Recommendation Report for Planning Permission for Works or Extension to a Dwelling

REF NO: AB/72/19/HH

LOCATION: 70 Church Cottages
Tortington Lane
Arundel
BN18 0BG

PROPOSAL: Construction of part two storey and part single storey side extension and associated works. This application may affect the setting of a Listed Building.

project	70 Church Cottages Torington Arundel West Sussex		
drawing	Elevations and Typical Cross Section As Proposed

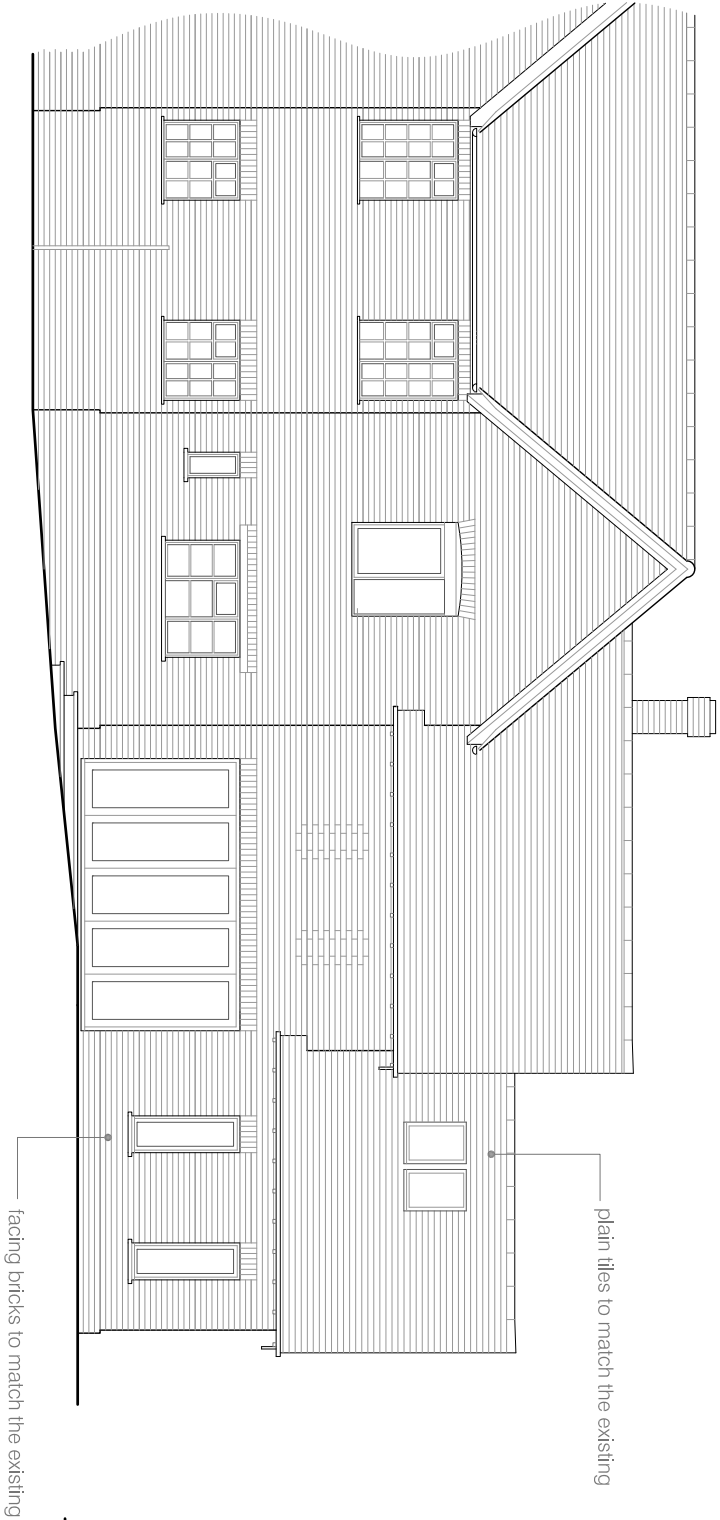
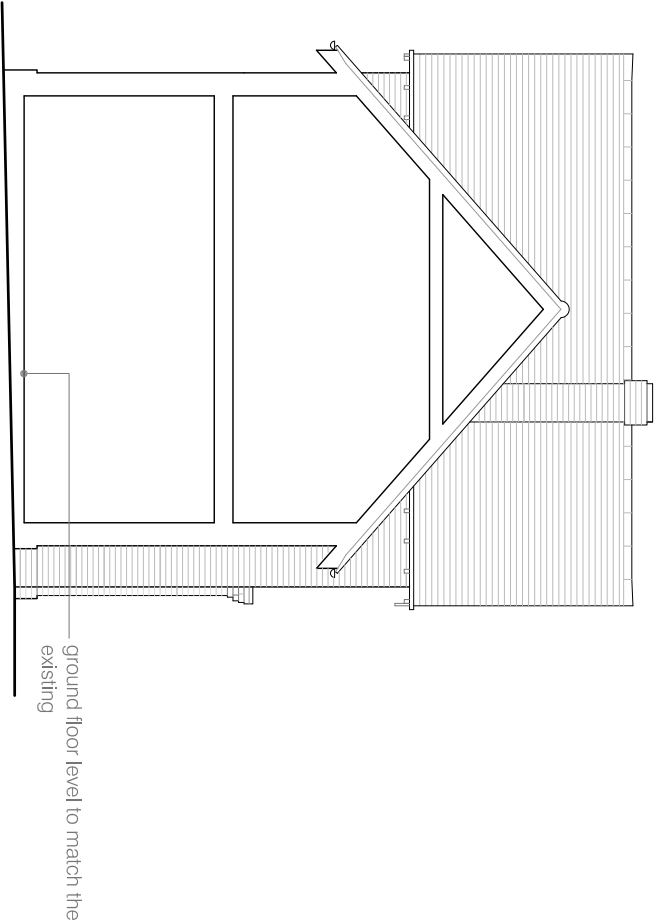
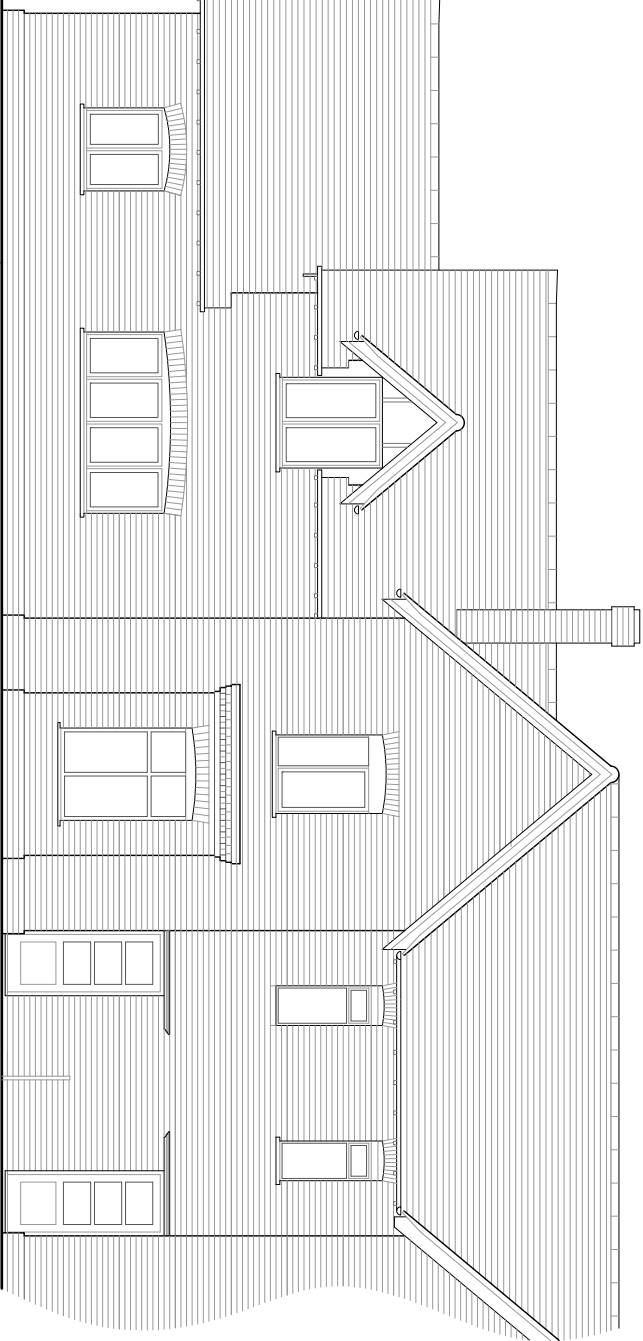
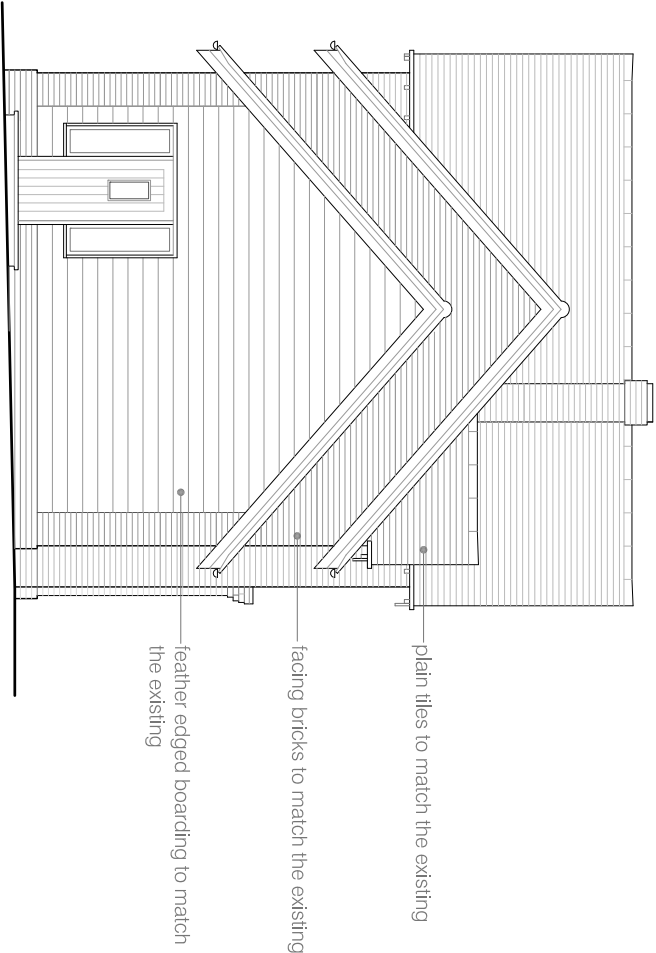
The proposed development is considered to represent an acceptable addition to the host dwelling, in that it has both a ridge height, and eaves height lower than the host dwelling, which allows to appear subservient to the host dwelling. The proposed materials are considered to allow the proposal to appear well integrated with the host dwelling, in that the brickwork will match that of the host dwelling, and cladding, as existing, has been moved to appear on the Northern elevation.
